DECISION DELEGATED TO HEAD OF PLANNING

Application No: H02-0783-24 **Applicant:** Mrs L Sboui

Proposal: Extension and conversion of single storey garage to ancillary annexe to main dwelling including improvement to parking spaces

Location: 164 Nene Terrace Road Crowland

Client	Mrs Louise M Sboui		
Project	Extension & Alterations Retirement Annexe 164 Nene Terrace Road Crowland PE6 0LH		
Drawing Title	Proposed Block Plan		
Drawn RAC	Date AUG2024	Checked —	Scale 1:200@A3
Job No NTR24	Drawing No 003	Revision —	Note

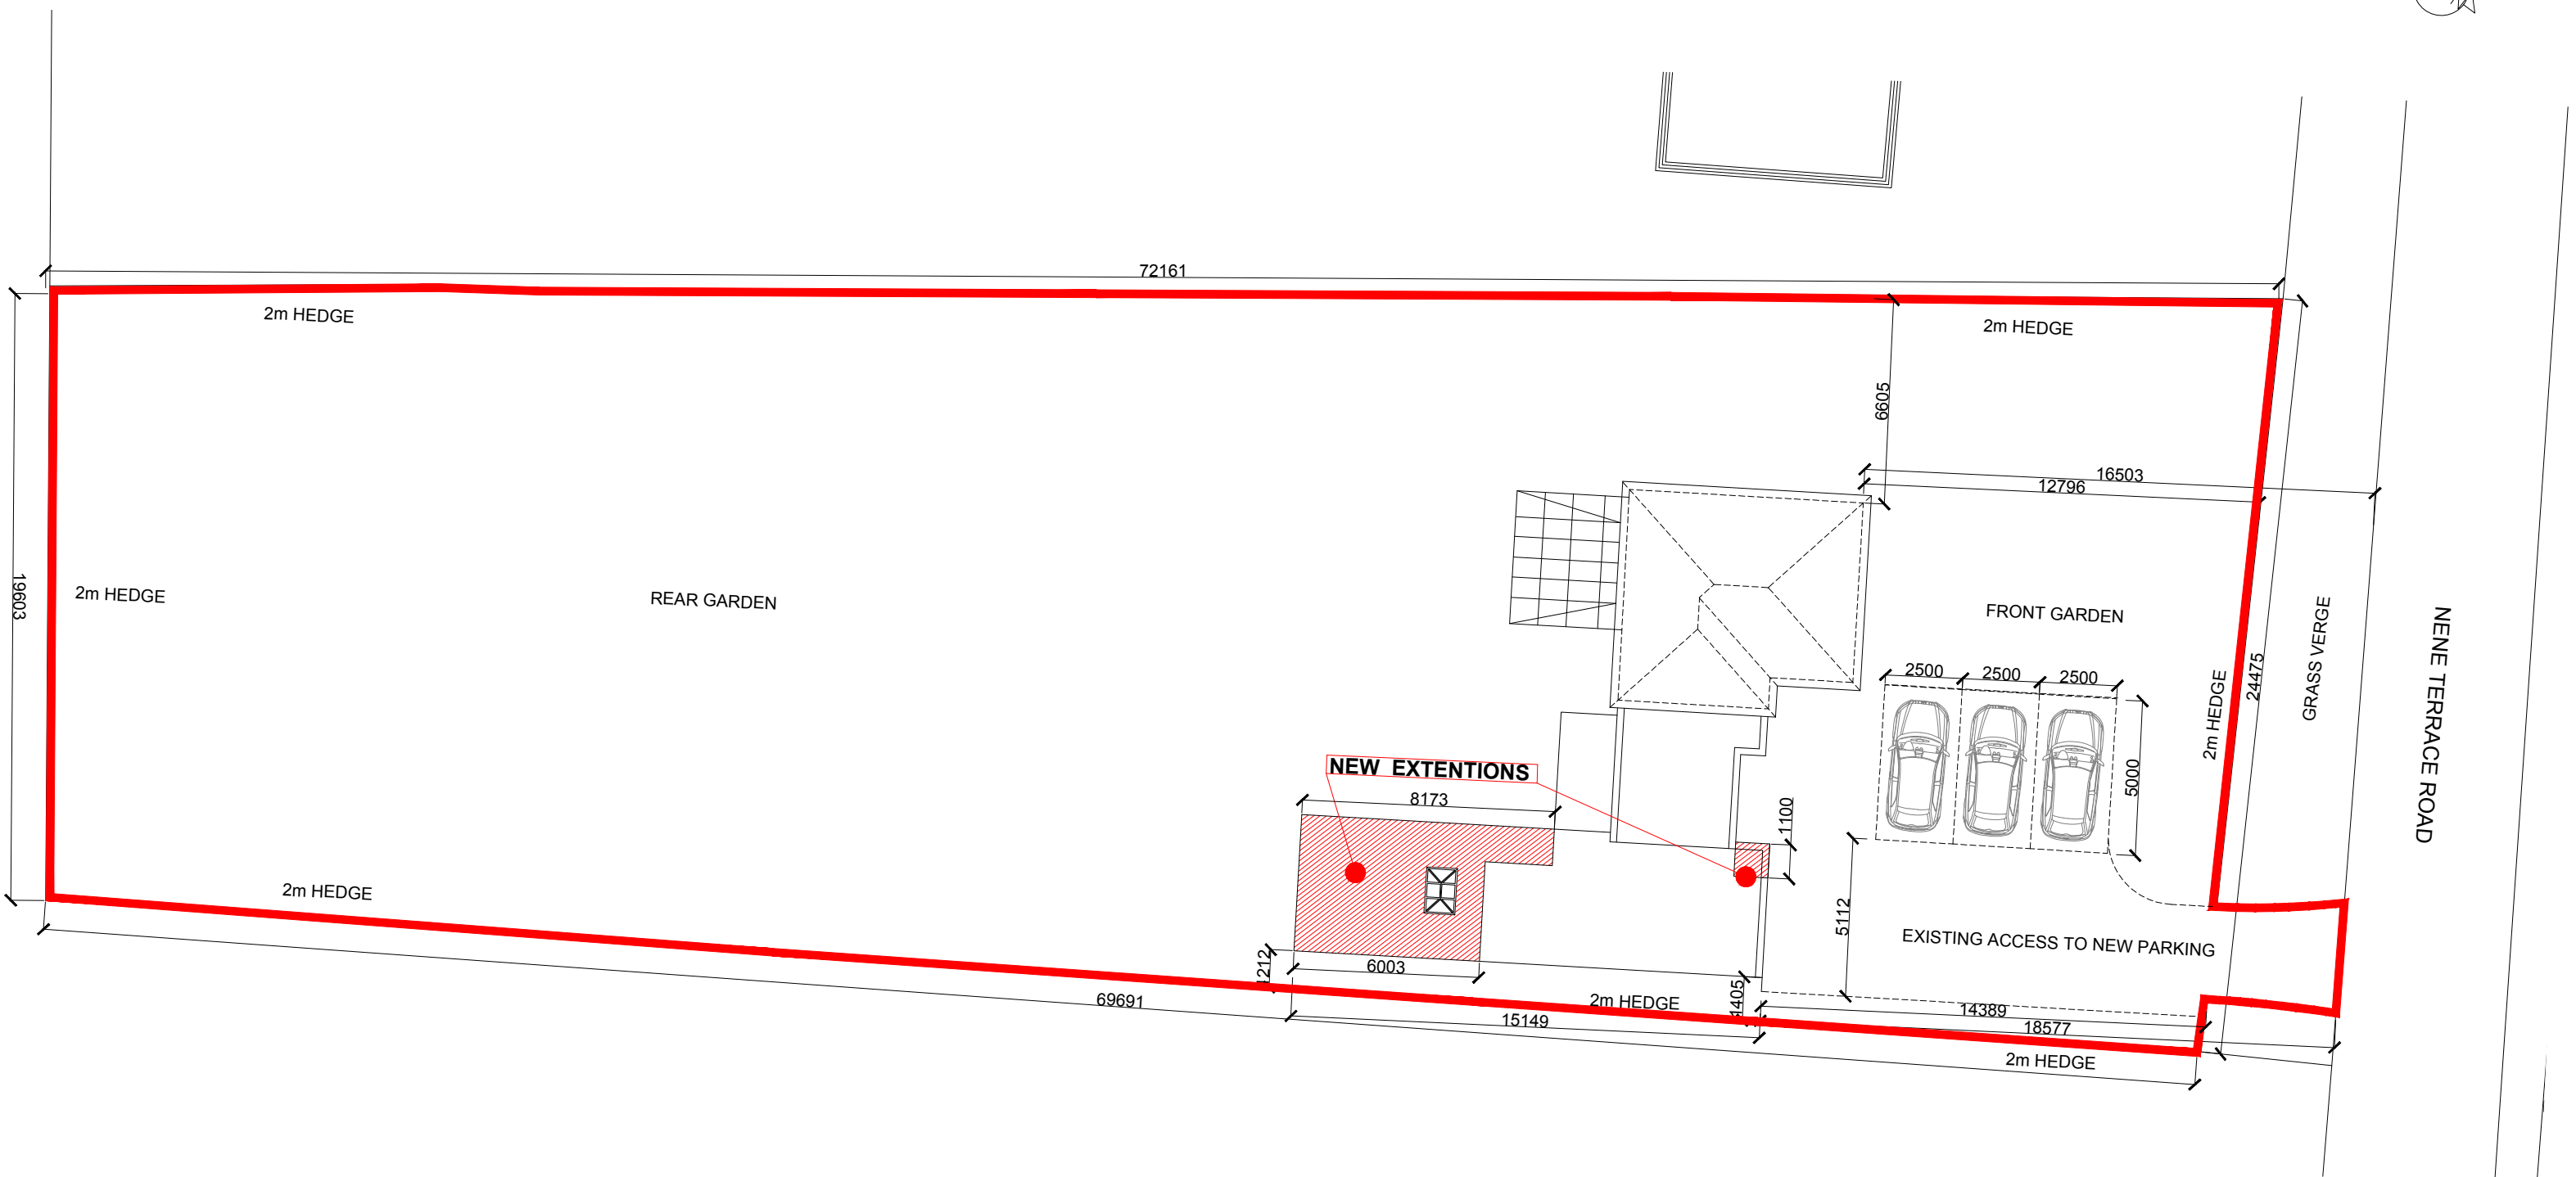
The number of bedrooms within the main dwelling is not confirmed, however, three parking spaces are proposed which should provide enough parking for both the main dwelling and the annexe. According to the application form, the expanded driveway area will be surfaced with gravel which is a permeable surface. The highways and sustainable drainage team at Lincolnshire County Council have been consulted on the application and have raised no objections to the proposed alterations to the driveway.

Proposed Floor Plan & Elevations

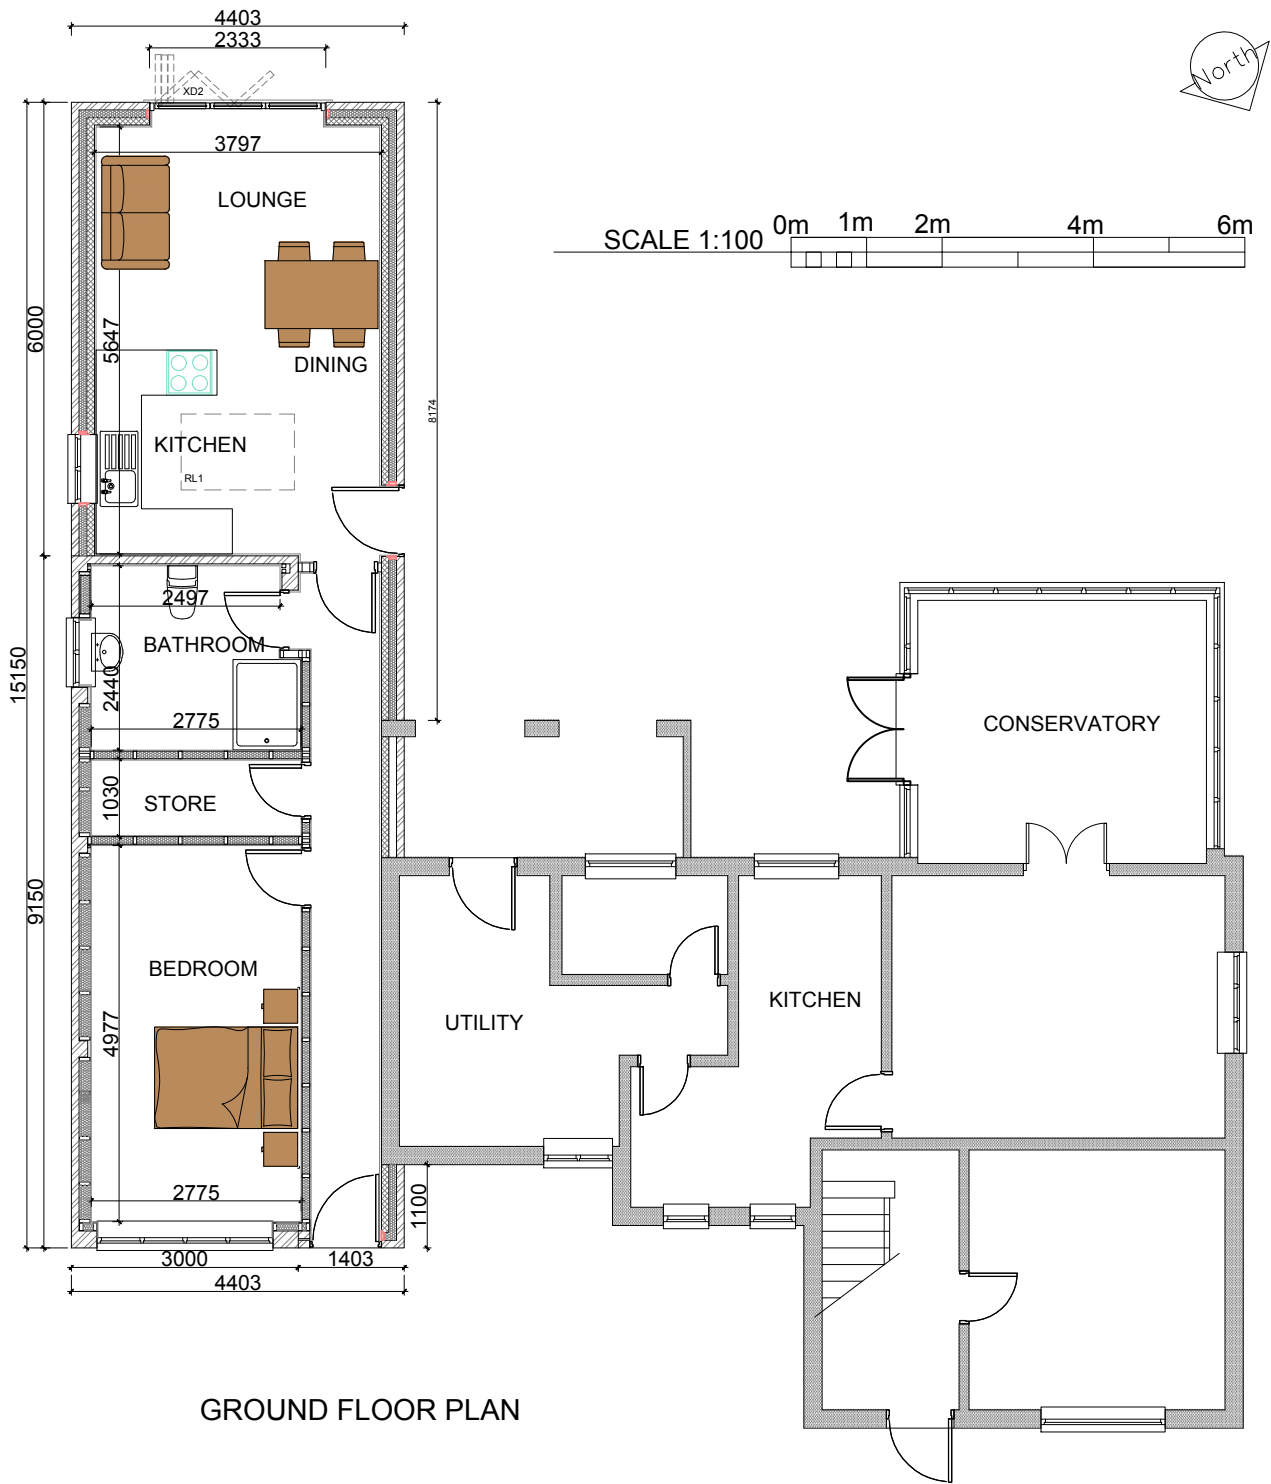
The proposal would increase the height of the side extension to 3m, to match the rest of the existing extension. The proposed materials use for the side extension would comprise brickwork to match the brickwork on the main dwelling. The existing roller shutter door would be replaced by a window and a doorway. The visual impact of this is acceptable.

The proposal also seeks to extend the existing garage to the rear by 6m. The proposed extension will continue to the flat roof form and is also proposed to be constructed using brickwork that matches the garage. The proposed extension would result in a relatively long extension compared to the main dwelling. The extension would however not be taller than the existing garage structure and the extension would be largely screened by an existing hedgerow which runs along the south-eastern boundary of the site. This therefore reduces the visual impact of the extension.

The proposed annexe would share an access, front driveway and garden space with the main dwelling. The annexe would have its own entryway which is separate from the main dwelling, therefore reducing the reliance of the annexe on the main dwelling. The proposed annexe also features approximately 55sqm of floorspace with a separate kitchen, living room, bathroom and bedroom. There is therefore sufficient living space that could allow an occupant to live independently. Notwithstanding this, overall it is considered that the annexe forms ancillary accommodation to the main dwelling. As set out previously, a condition can be attached to ensure that the use remains ancillary and cannot be used for any other purpose.

For example, the proposed extension is single storey and is not positioned next to the neighbouring property. The proposed new windows are located on the south-eastern elevation which does not look onto any neighbouring properties. Therefore, the impact of the proposed extension on the amenity of neighbouring properties would be acceptable. As such, the proposed development accords with Policies 2 and 3 of the Local Plan and Section 12 of the NPPF.

PROPOSED ROOF PLAN

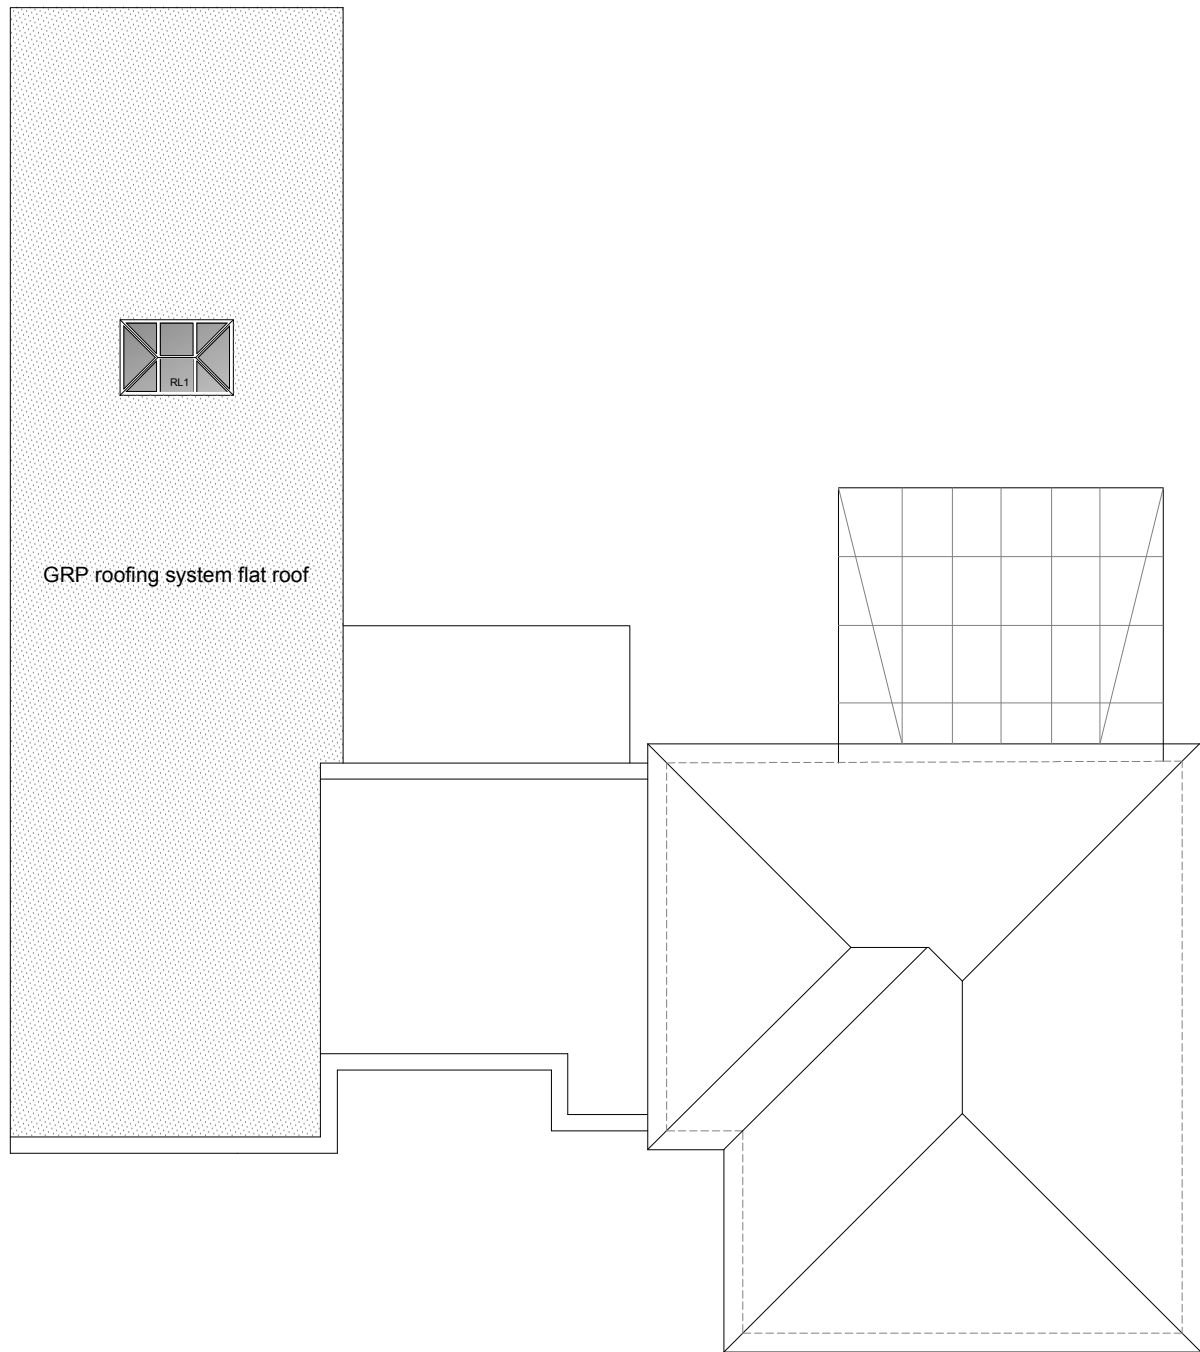
A roof lantern is proposed on the rear extension. The applicants agent has clarified that the roof lantern would not project above the roofline and as such would not be visible.
